From: Paul Cann <Paul.Cann@arun.gov.uk>
Sent: 26 May 2022 13:30
To: Planning.Responses <Planning.Responses@arun.gov.uk>
Subject: RE: Planning Consultation on: F/5/22/DOC

Application No: F/5/22/DOC
Registered: 24th May 2022
Site Address: Wicks Farm Ford Lane Ford BN18 0DF
Description of Works: Approval of details reserved by condition imposed under F/7/21/PL relating to conditions 3-surface water drainage scheme, 4-discharge of flows to watercourses, 5-maintenance and management of surface water drainage, 6-landscape screening scheme, 7-contamination and 9-ecological enhancements.

From: Paul Cann
Sent: 26 May 2022 13:22
To: Stuart Magowan
Cc: John Hall; David Moore; CEP | Reception; Anita Gardner
Subject: RE: 23482 Wick Farm East - F/7/21/PL Planning Conditions 3 and 5

CONCRETE YARD SECTION
(Scale 1:20)

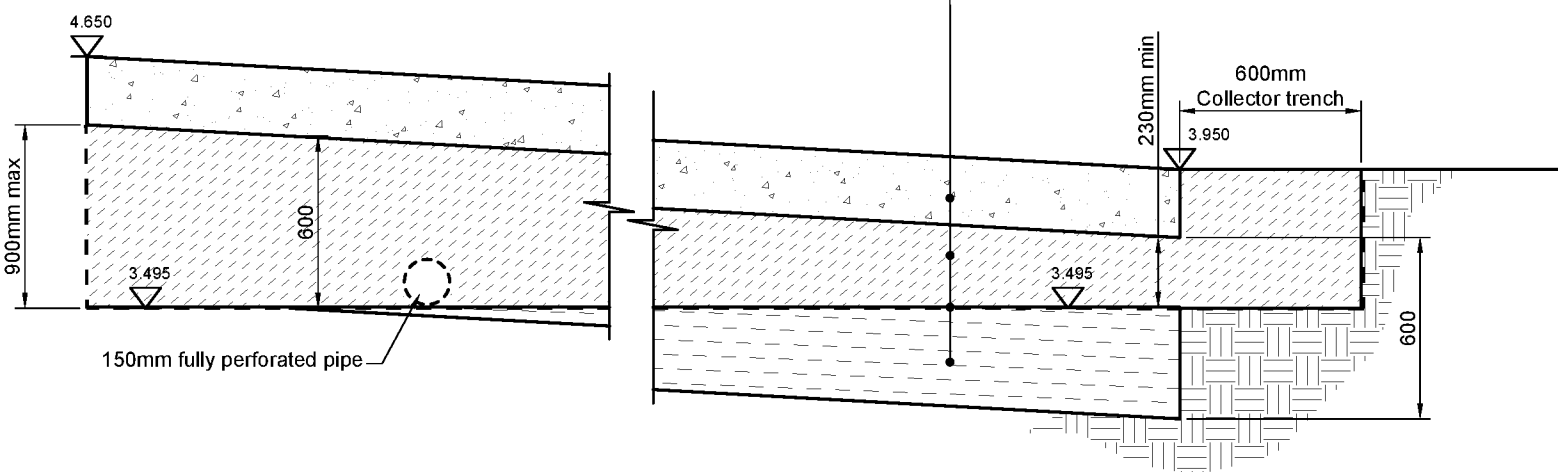
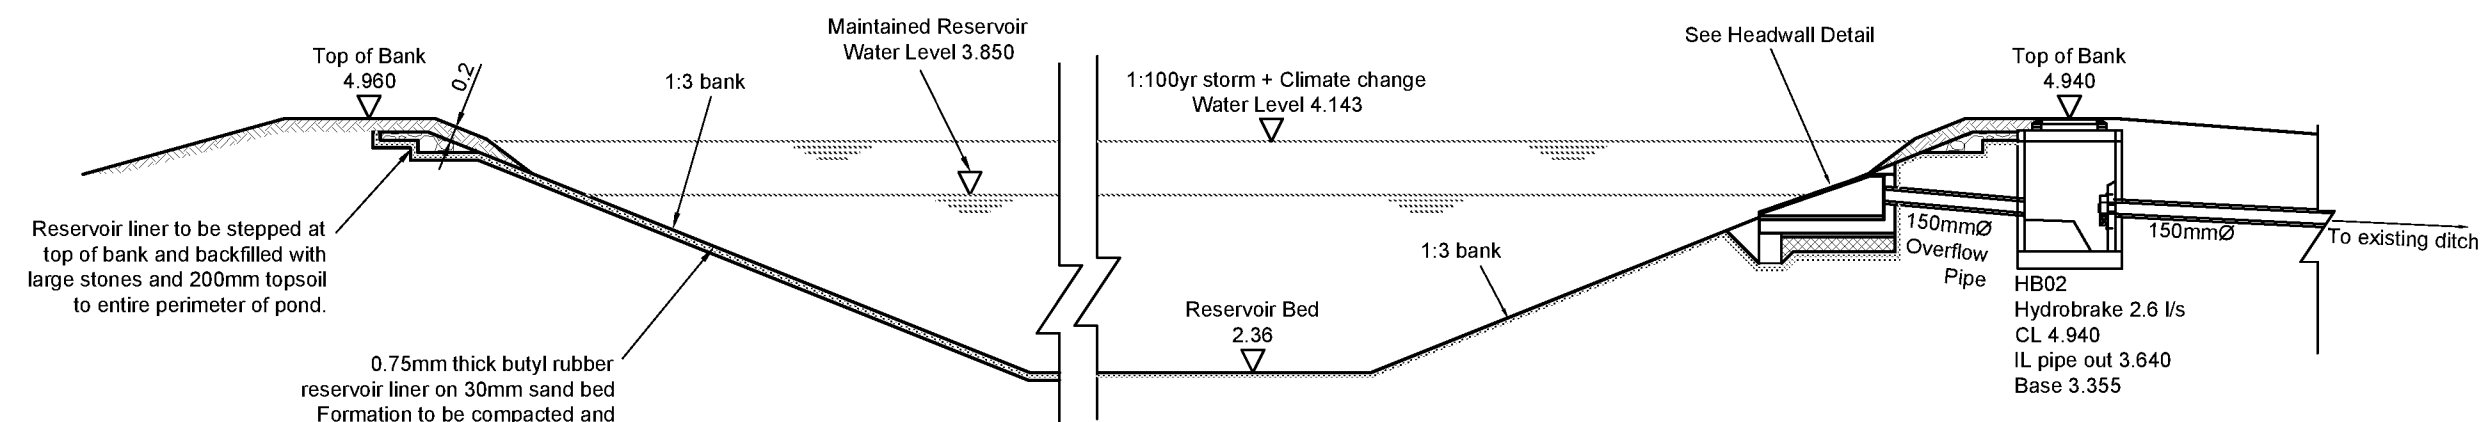
9. **Specify formation levels of yard structure on both the plan and construction detail.** Noted and included on plan and construction details drawing 502A copy attached ok

10. Specify formation levels of yard structure on both the plan and construction detail.
11. Type C manhole – indicate PPC cover slab to suit. Clearly indicate the PCC rings and 150mm concrete surround.

RESERVOIR SECTION
(Scale 1:100)

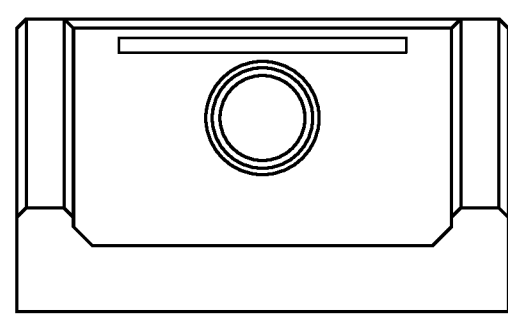
14. **Provide reservoir construction details.** Noted and included on drawing 502A Indicate how the butyl liner accommodates the headwall structure to achieve a sealed system. Detail updated on drawing 502B.

CLIENT	DPS Limited				
PROJECT	Wicks Farm - East, Ford Lane				
TITLE	Site Layout - Proposed Drainage And Levels				
DRAWN	A Davies	DATE	Feb 2022	PROJECT NO.	23482
ENGINEER	S Magowan	CHECKED	SRM	DRG. No.	101
SCALE	1:500 @ A1, 1:1000 @ A3			REV.	C

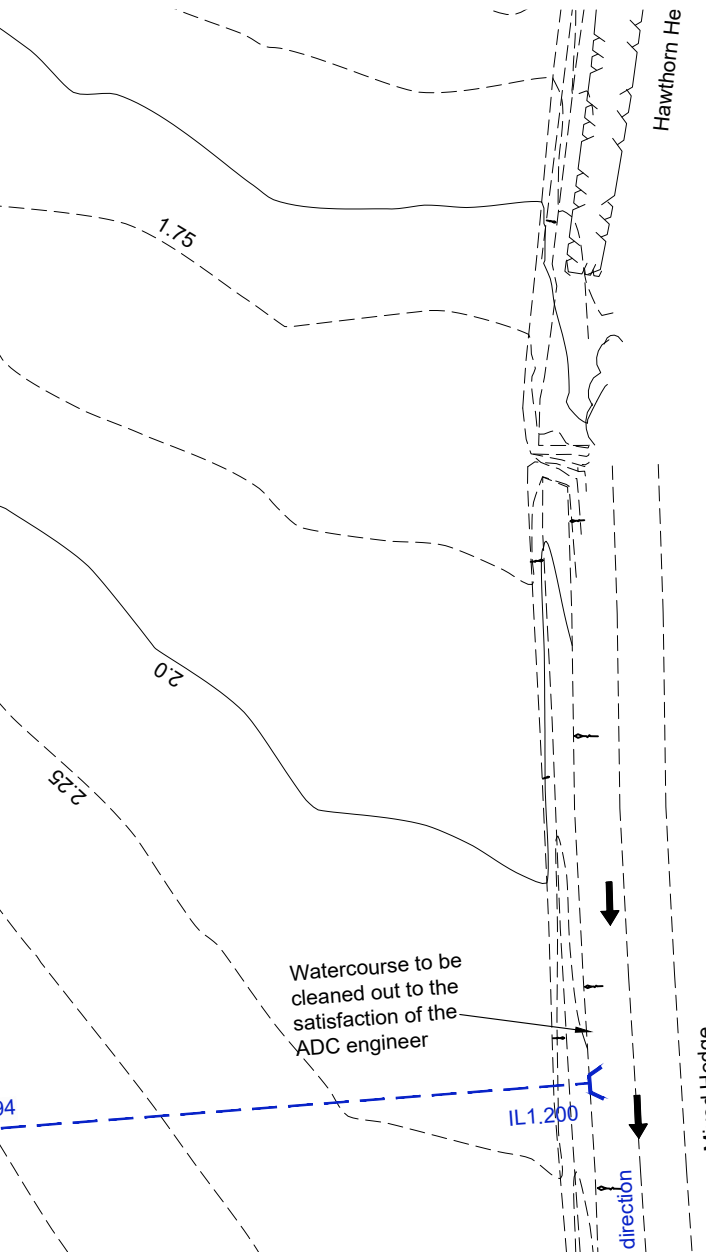
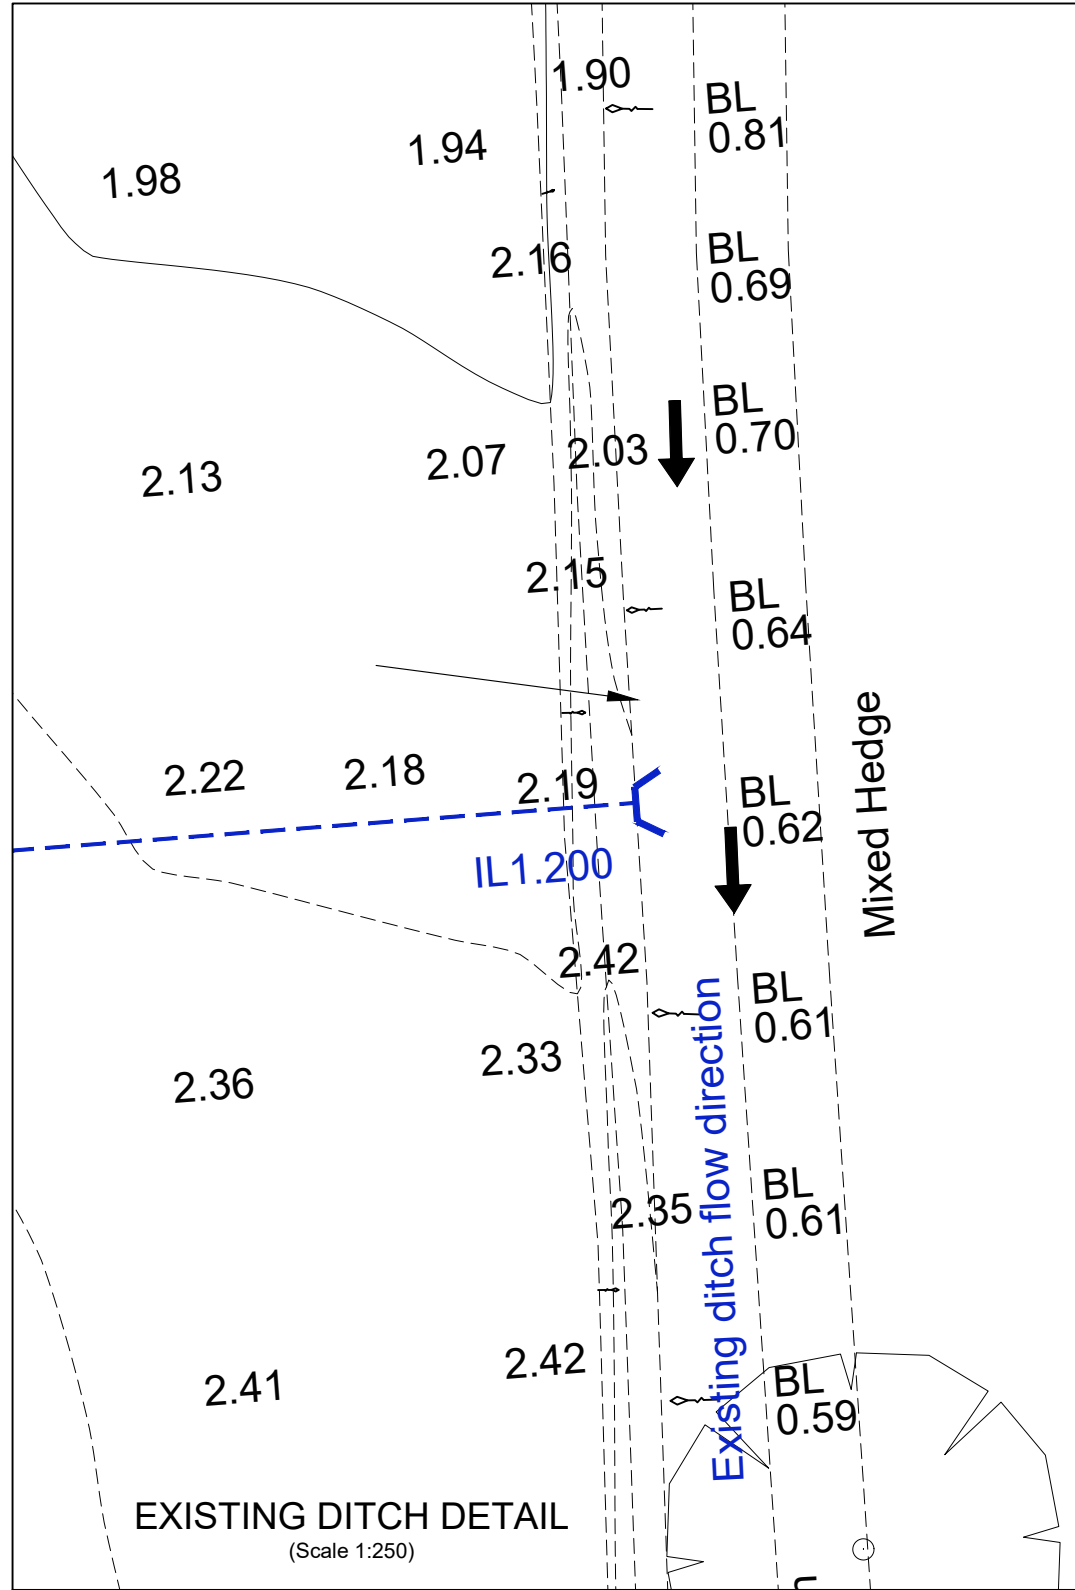
3. **Pipe lengths S02 – S03 – S04 – S05 – S06 – S07 – Specify min. gradient 1 in 150.** A gradient of 1/167 provides self-cleansing velocity in accordance with building regulations for private drainage of this size. The surface water system will remain private and is not being offered for adoption. Sewers for Adoption requires a velocity of 1 m/s, however for a private system BSEN 752 and Building Regulations Part H apply and require a minimum velocity of 0.7 m/s. The velocity of the system will determine the depths of the pipework, as a higher velocity will increase a lot of the gradients, this will increase the depth of the system and subsequently increase the depth of excavation during construction needlessly. The system has been designed using a minimum velocity of 0.75 m/s which is acceptable based on policy and relevant regulations See item 2 above. Noted

5. Provide additional topo survey data for the existing ditch ie. existing bed levels. Are there culverts immediately downstream? Levels? As much freeboard as possible needs to be achieve between the invert of your connecting pipe and ditch bed. We have included additional levels taken within the ditch, this has been added onto the layout drawing 101 B ok

6. **Indicate flow direction of watercourse.** At the point of connection, it flows from north to south, direction has been added to drawing 101B ok
7. **Add note 'Watercourse to be cleaned out to the satisfaction of the ADC engineer'.** Note added to drawing 101B ok

8. **Collector trench for yard – alter note to refer to drg. 502 as opposed to 501.** Correct the 600mm dimension (shown as 600nn). Specify length of trench. Noted and updated on 101B ok

1. Ground conditions are assumed to be similar to the adjacent site, therefore infiltration has been ruled out.
2. Clearly indicate invert of outgoing pipe from reservoir ie. 3.85m.
3. Pipe lengths HB02 – S10 – S11 – S12 – Specify min. gradient 1 in 150.
4. Pipe lengths S02 – S03 – S04 – S05 – S06 – S07 – Specify min. gradient 1 in 150.
5. The FRA discussed the use of an open channel conveying water to the existing ditch, as opposed to pipework. Was there a reason for discounting this in the detailed design?
6. Provide additional topo survey data for the existing ditch ie. existing bed levels. Are there culverts immediately downstream? Levels? As much freeboard as possible needs to be achieved between the invert of your connecting pipe and ditch bed.
7. Indicate flow direction of watercourse.

8. Add note 'Watercourse to be cleaned out to the satisfaction of the ADC engineer'.
9. Collector trench for yard – alter note to refer to drg. 502 as opposed to 501. Correct the 600mm dimension (shown as 600nn). Specify length of trench.
